DRB Application No.: 05DRB-01744 (SBP)
Project Name: THE FALLS RESTAURANT
Agent: CBL Architects

DEVELOPMENT REVIEW BOARD
TRANSPORTATION DEVELOPMENT
Standard Comment Sheet

DRB- 1004366 Item No. 9 Zone Atlas A-14

SUBJECT: Project # 1004366

PROJECT	REVISIONS
THE FALLS RESTAURANT	
JOB NUMBER	0503
SHEET TITLE	
SITE PLAN	
C-B-L ARCHITECTS, LTD.	
ARCHITECTS + PLANNERS, AIA	
1700 LOUISIANA BLVD NE, SUITE 300 ALBUQUERQUE, NM 87110	
PHONE (505) 765-1020 FAX (505) 765-9205	
DATE	SHEET NO.
11/15/05	DRB 1.0

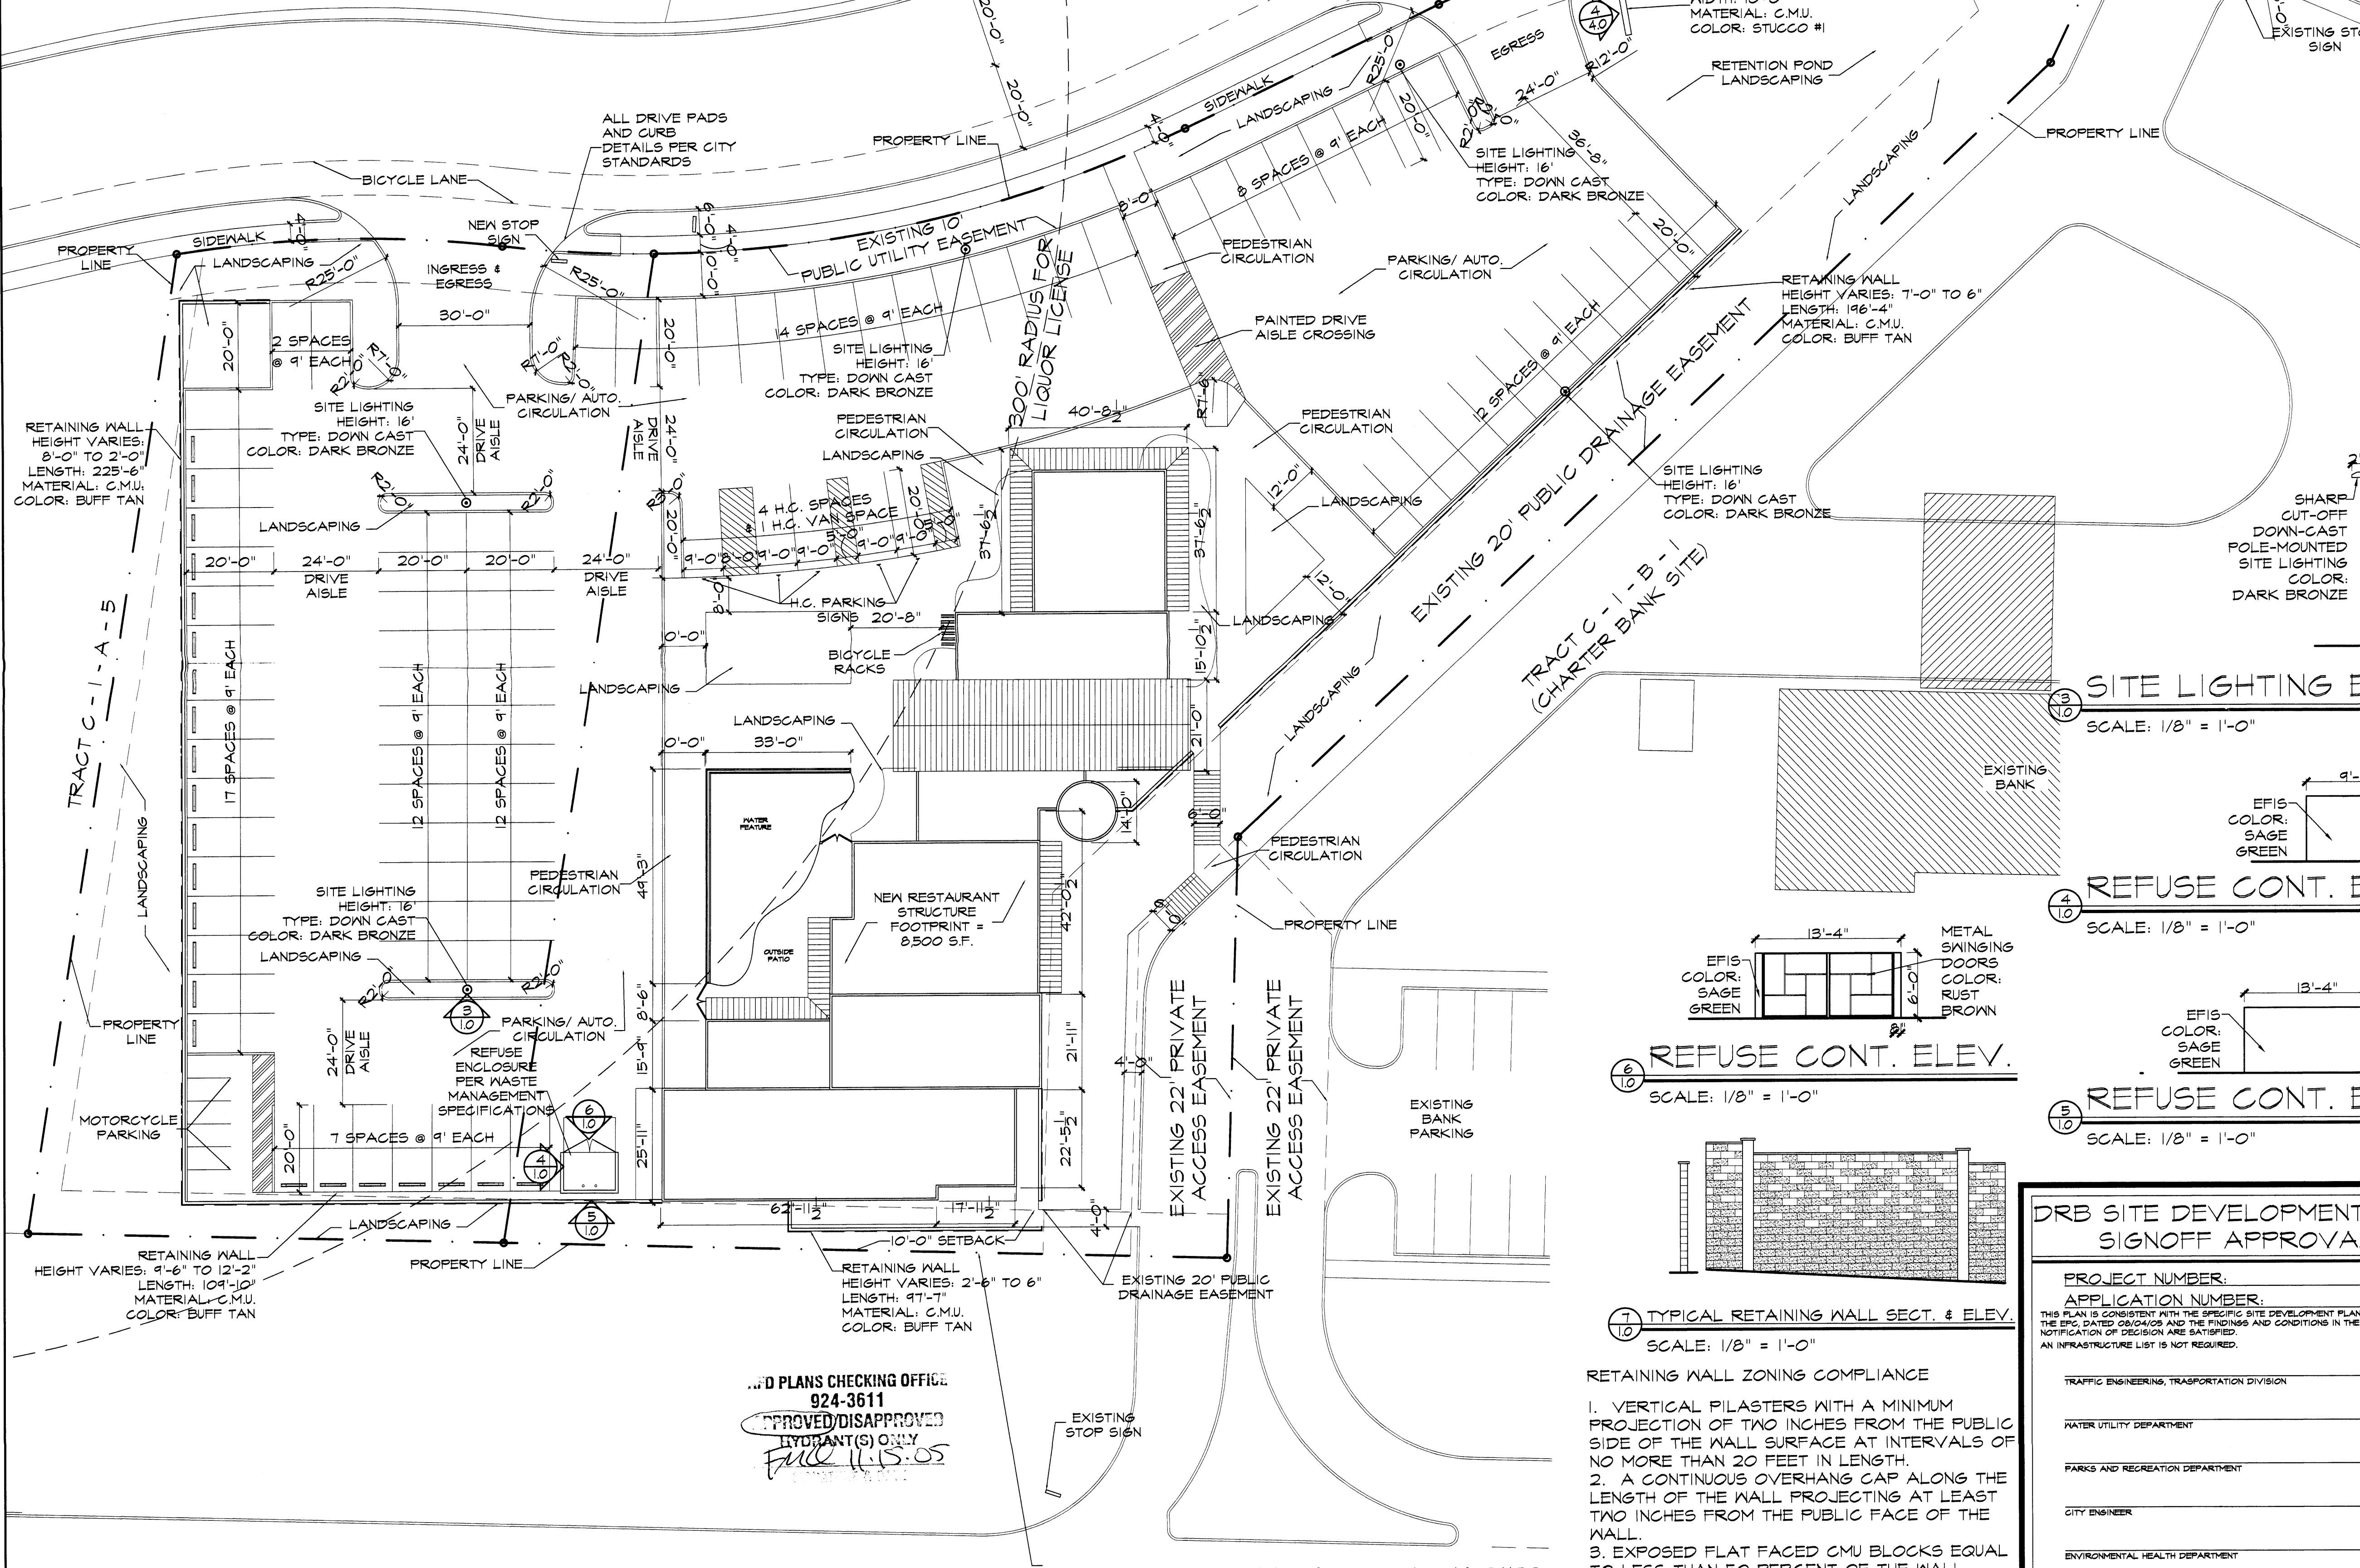
- 1) Applicant will need to coordinate with NMDOT regarding sidewalk along NM 528. (Meeting)
- 2) The end islands for the parking lot do not meet DPM requirements. Radii need to meet DPM requirements. ??
- 3) Is the bicycle lane existing? YES
- 4) Where are the COA standard drawing numbers for the drive returns? ??
- 5) Is the sidewalk existing along American Road? ^{BUILD NOTES} ADA ramps? ~~---~~
- 6) Unsure how x-access will work with property to the west? ~~---~~
- 7) Ensure sight distance can be met with landscape plan. ✓

PLANT LEGEND

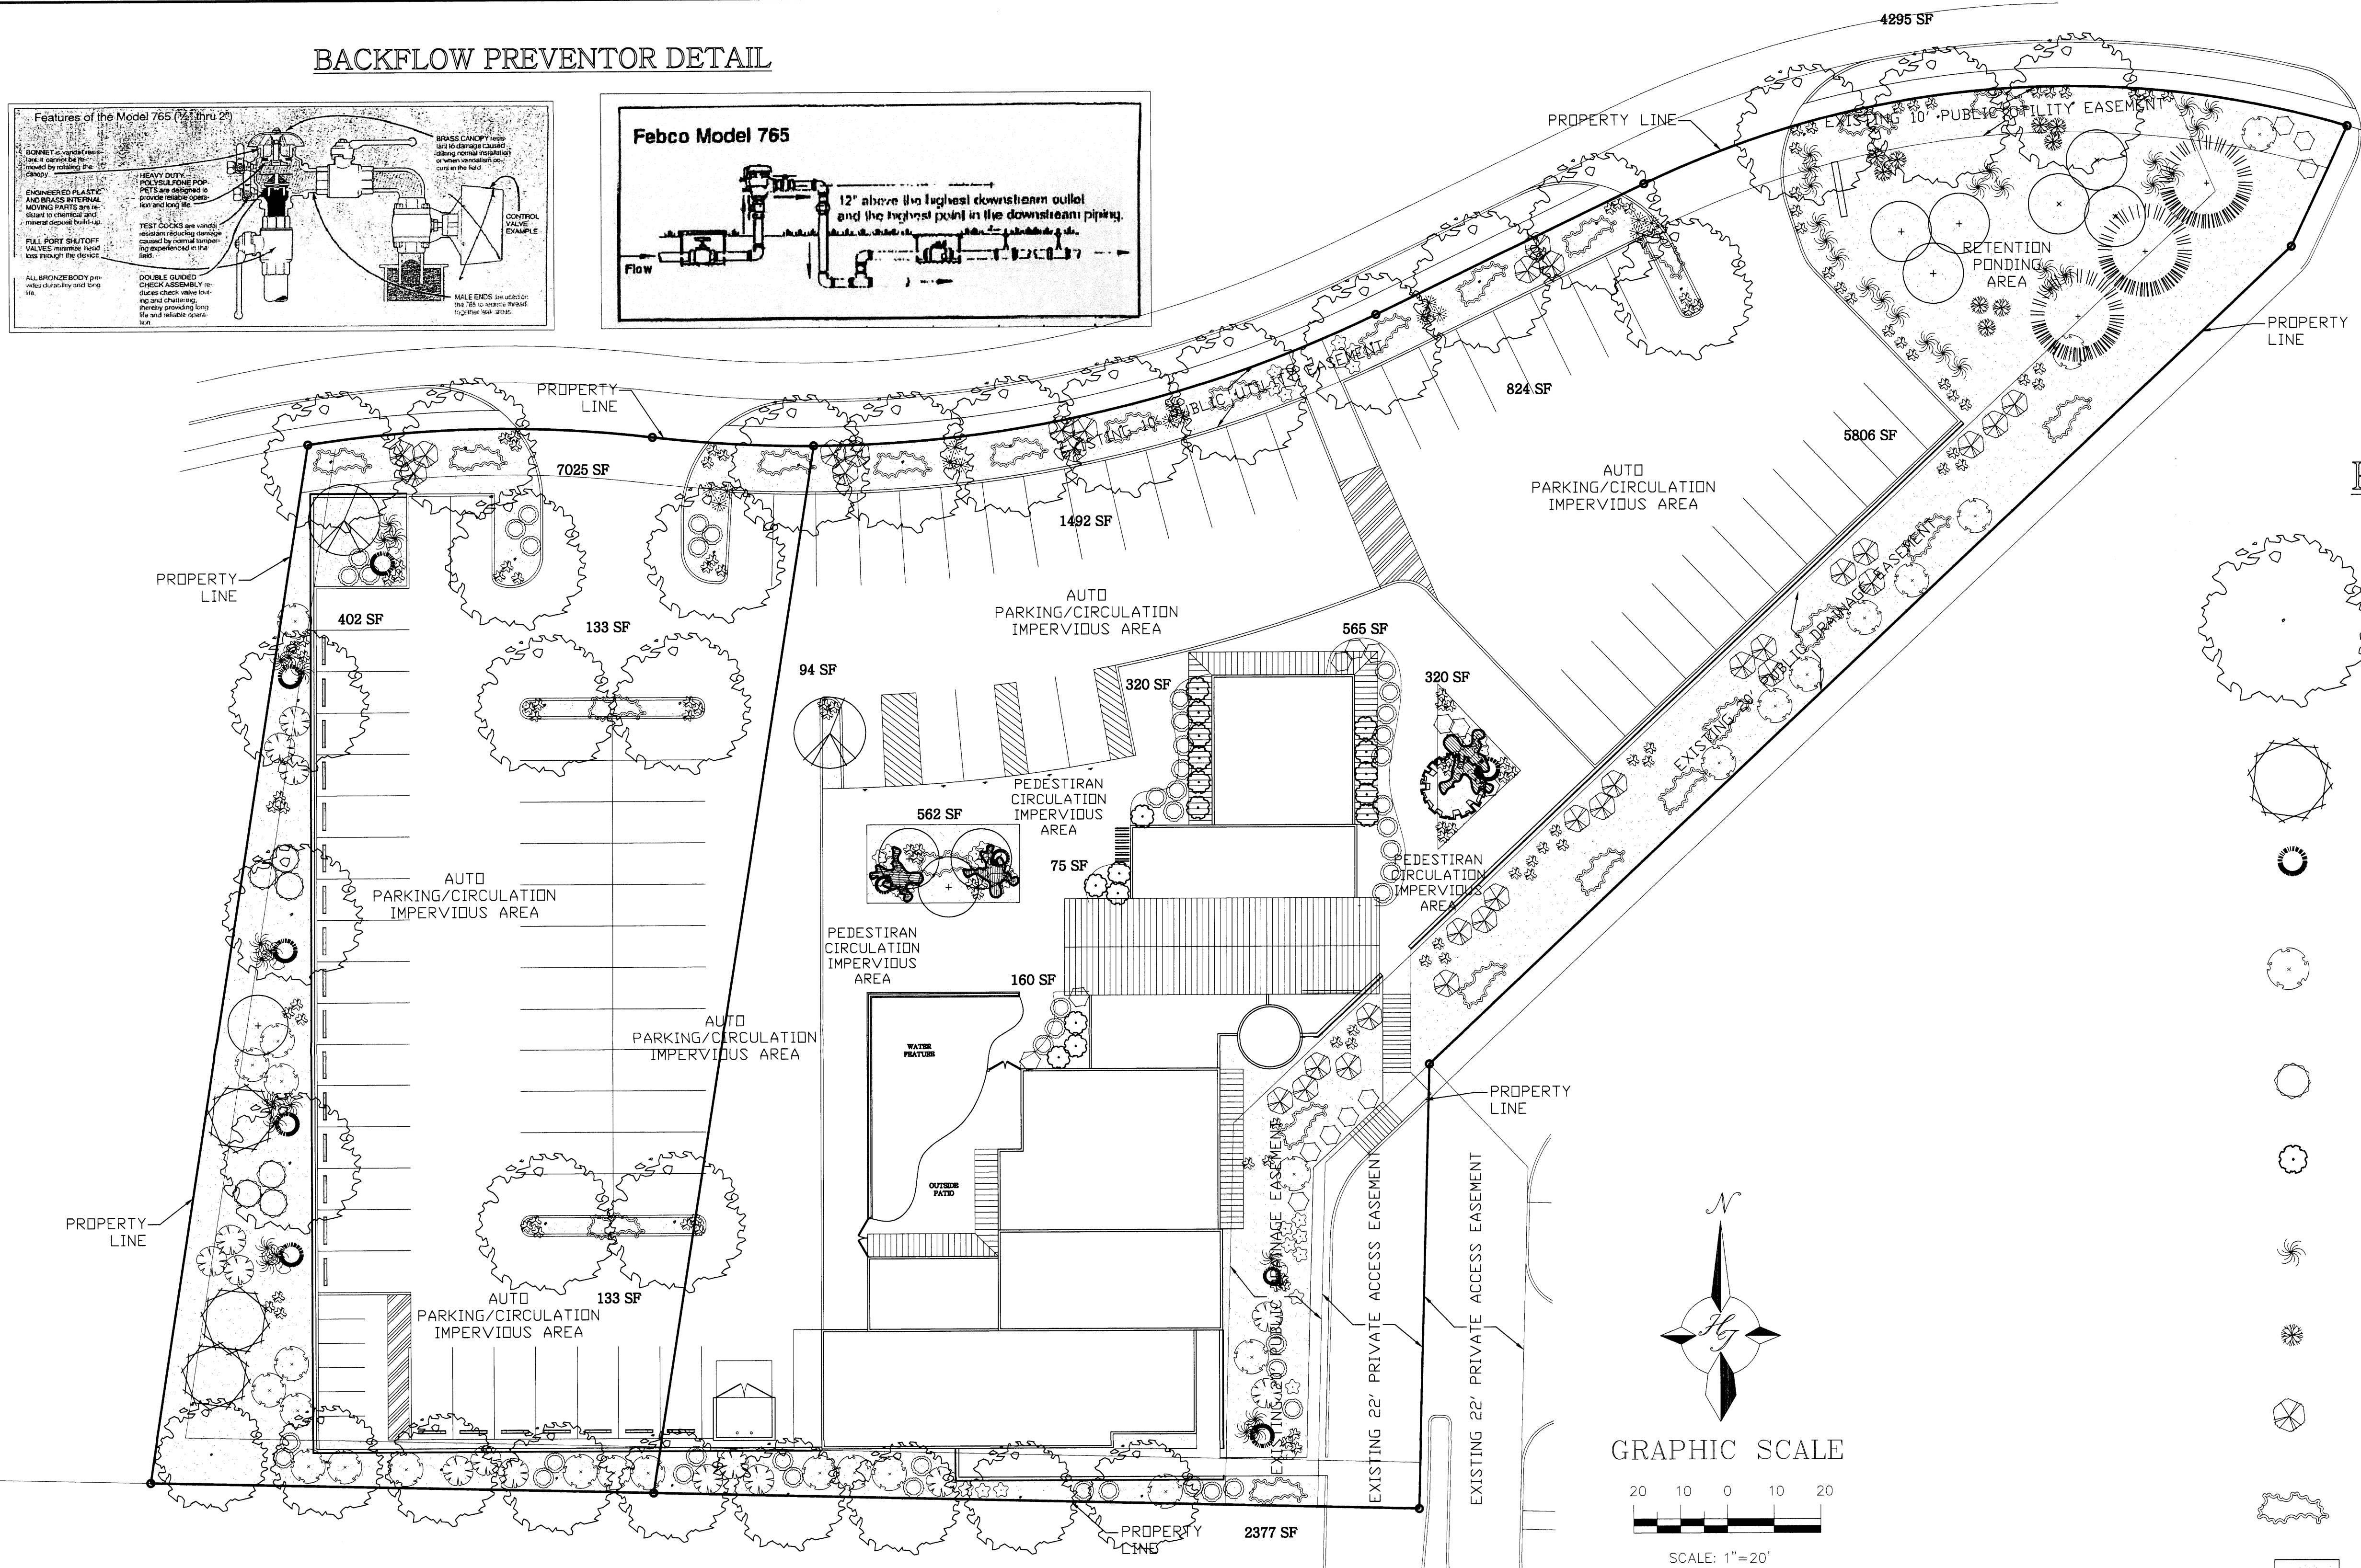
- 14c. The Landscape Plan shall be modified to show the required 10' landscape buffer along the entire south property line.

- 14f. The landscape plan shall be modified to show the required off-street parking area trees (1 tree/10 spaces) and additional shade trees within the western most landscape buffer.

Because of the proposed retaining wall on the south property line near the southeast corner of the site, the full 10' landscape buffer is not possible at this location.

The existing drainage easement on the eastern portion of the site precludes the required number of off street parking area trees from being planted. The applicant has made an effort to provide as many trees as possible outside of the drainage easement.
